**App no: 26.0027**

**Address: Land at Highmoor Farm Clitheroe**

**Proposal: Non material amendment to application 3/2020/0601 to amend the wording of conditions 12, 13 and 17 to include a reference of the approved access drawing.**

client: morris homes
 project: highmoor farm, clitheroe
 project number: J329224
 scale: 1:500@A3
 drawing title:
 preliminary site access
 drawing number:
 J32-9224-PS-001

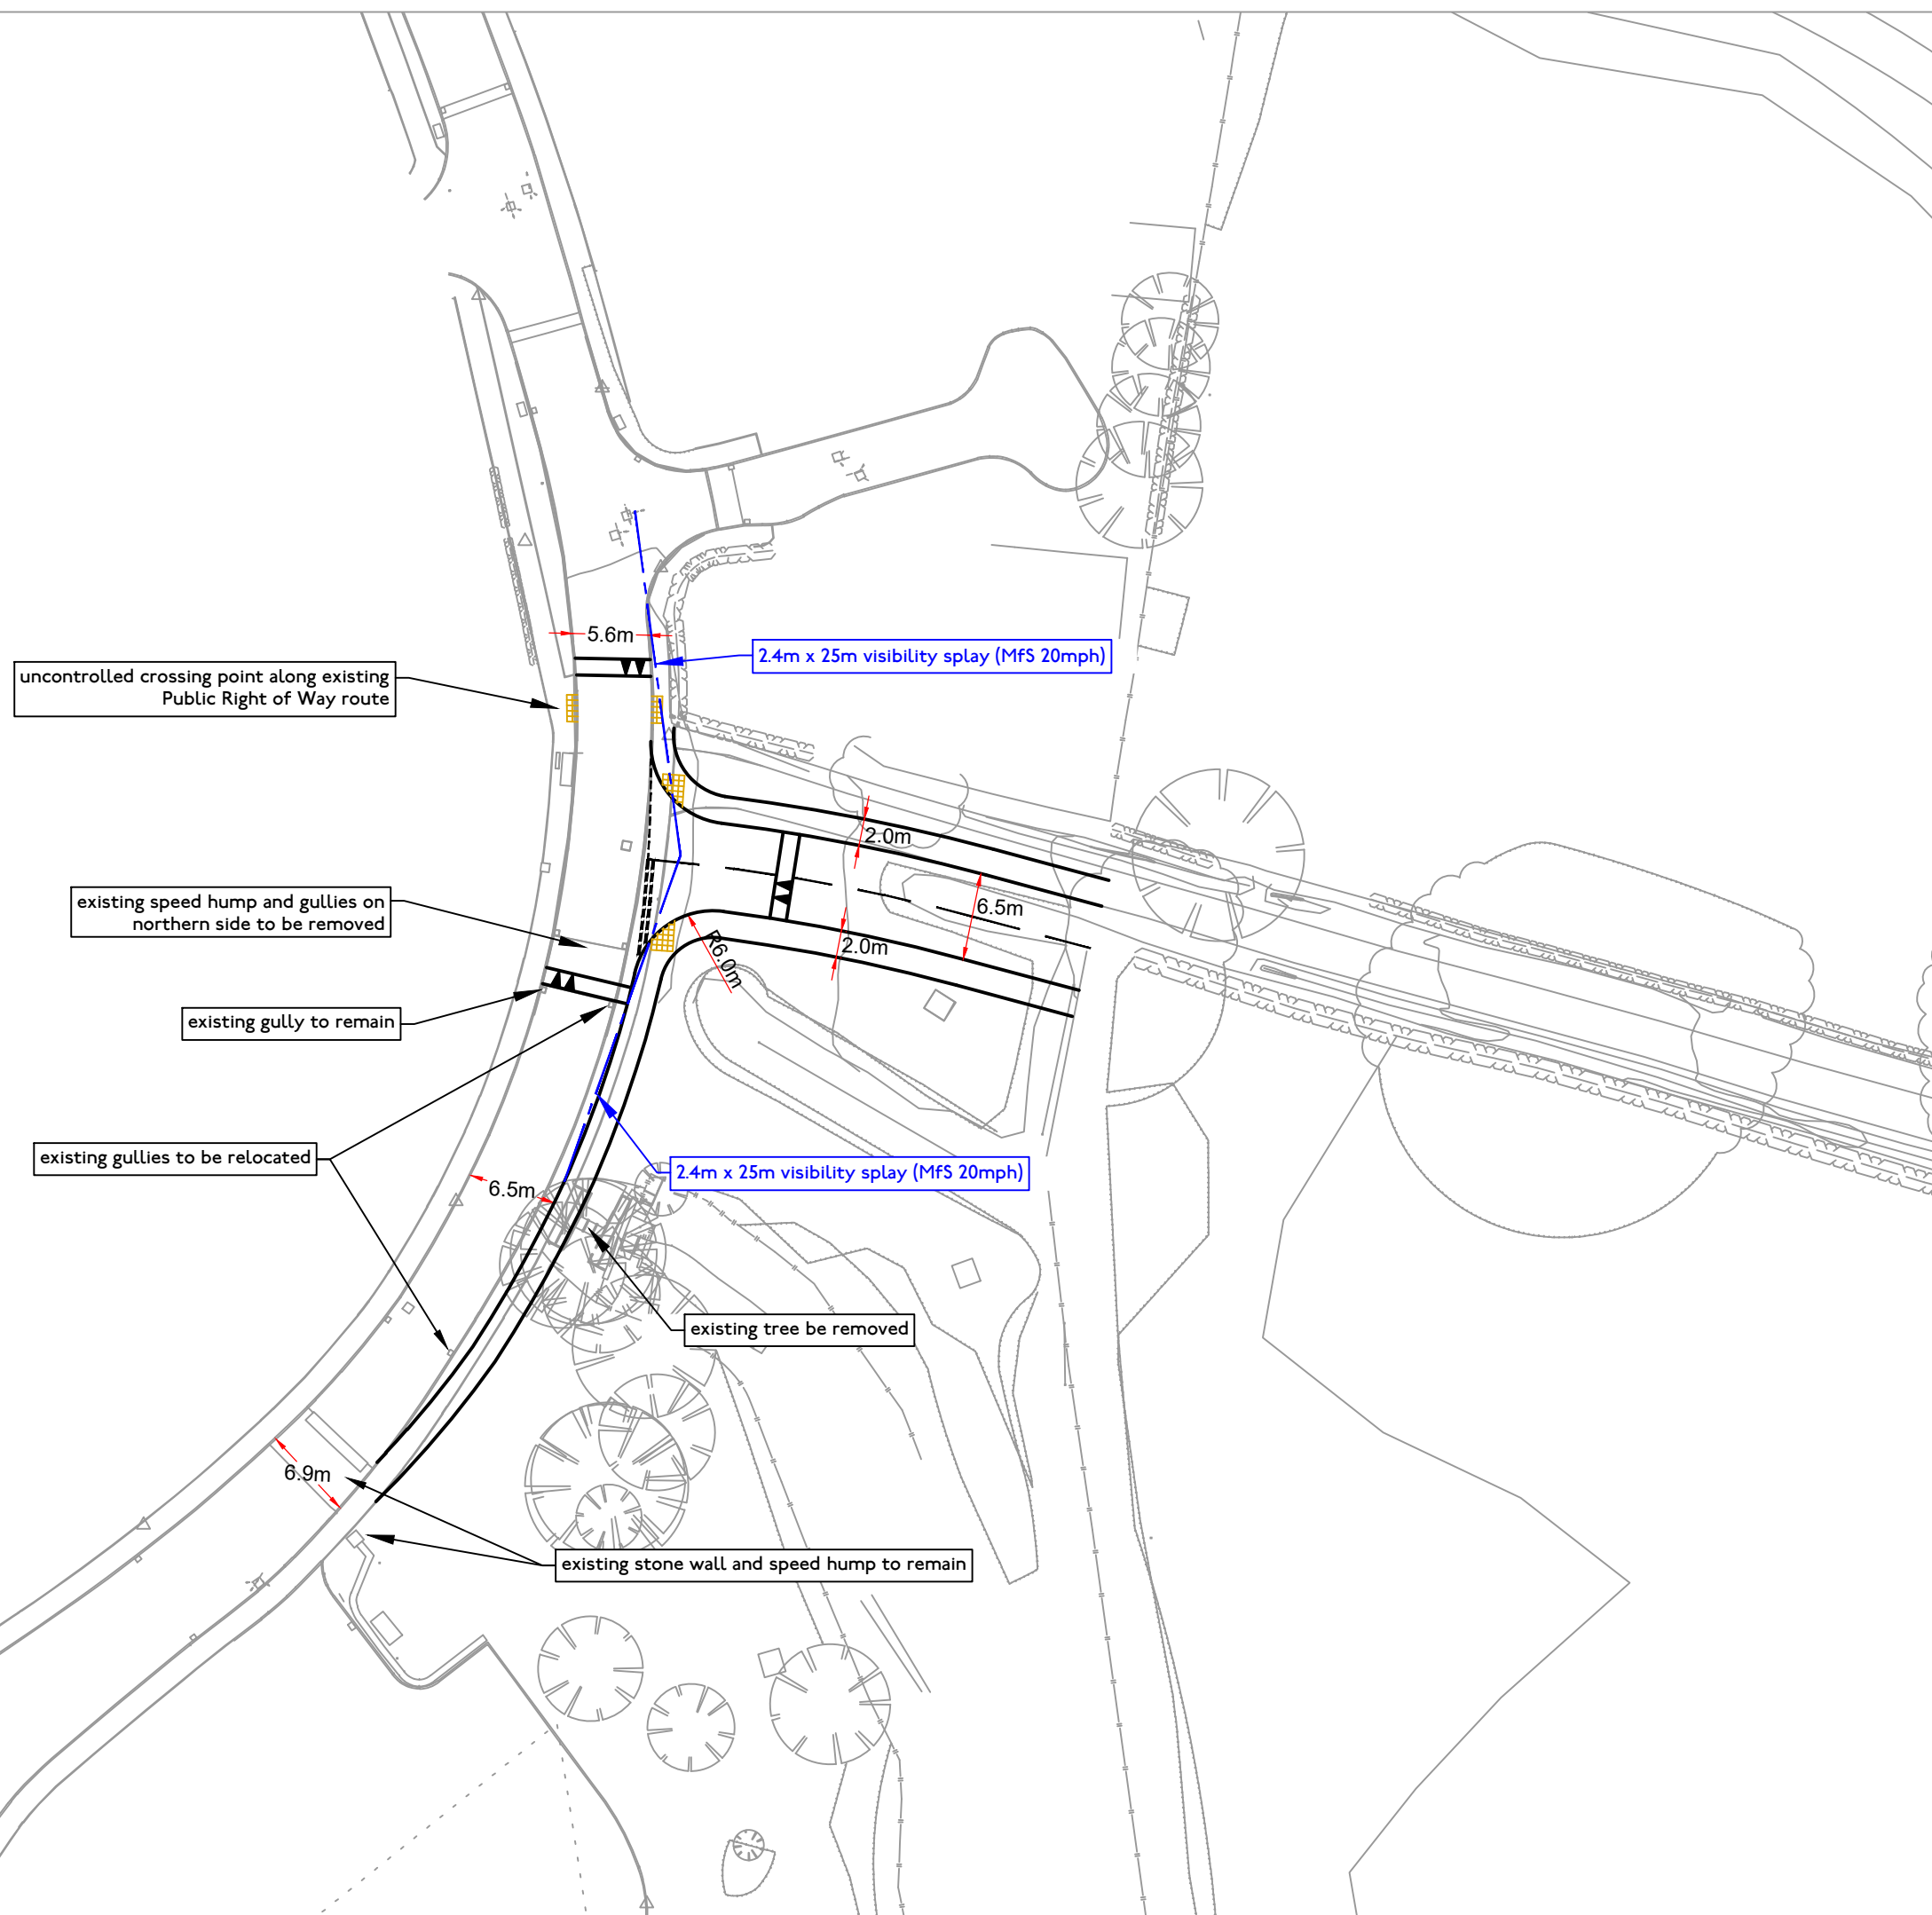
Highway Authority response – There is no objection to the variation of wording. The submitted drawing Plan Ref J32-9224-PS-001 (Mode Transport Planning) Rev C 5/5/2026 is considered acceptable and is subject to technical approval through the S278 process including any technical design changes which are considered necessary through the process and safety audit.

The proposed access from the site to Highmoor Park shall be constructed to a width of 6.5m with 2m footways on either side. As shown on approved Plan Ref J32-9224-PS-001 (Mode Transport Planning) Rev C 5/5/2026.

Highway Authority response – We would raise no objection to the proposed variation of wording.

No dwelling shall be occupied until visibility splays 2.4 metres back from the centre line of the access and extending 25 metres on the nearside carriageway edge in both directions have been provided at the access as shown on the approved plans, Ref J32-9224-PS-001 (Mode Transport Planning) Rev C 5/5/2026. Nothing shall be erected, retained, planted and / or allowed to grow at or above a height of 0.9 metres above the nearside carriageway level which would obstruct the visibility splay. The visibility splays shall be maintained free of obstruction at all times thereafter for the lifetime of the development

Highway Authority response – We would raise no objection to the proposed variation of wording.
